# Rezoning Transportation Analysis

Petition Number: 2020-168

General Location Identifier: Tax ID 10110157

SHEET NO:
RZ-1

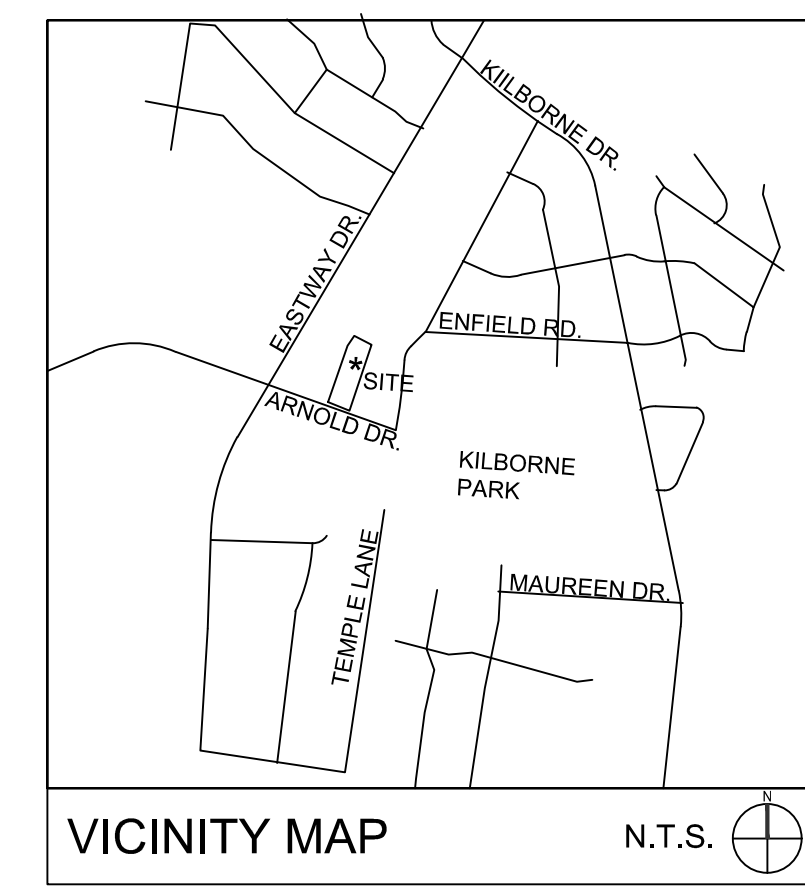
The site is located on a minor collector [Arnold Drive]. As this is a conventional rezoning petition, CDOT will request an 8-foot planting strip and 6-foot sidewalk to be installed during permitting. CDOT will work with the petitioner during permitting to determine any other development requirements.
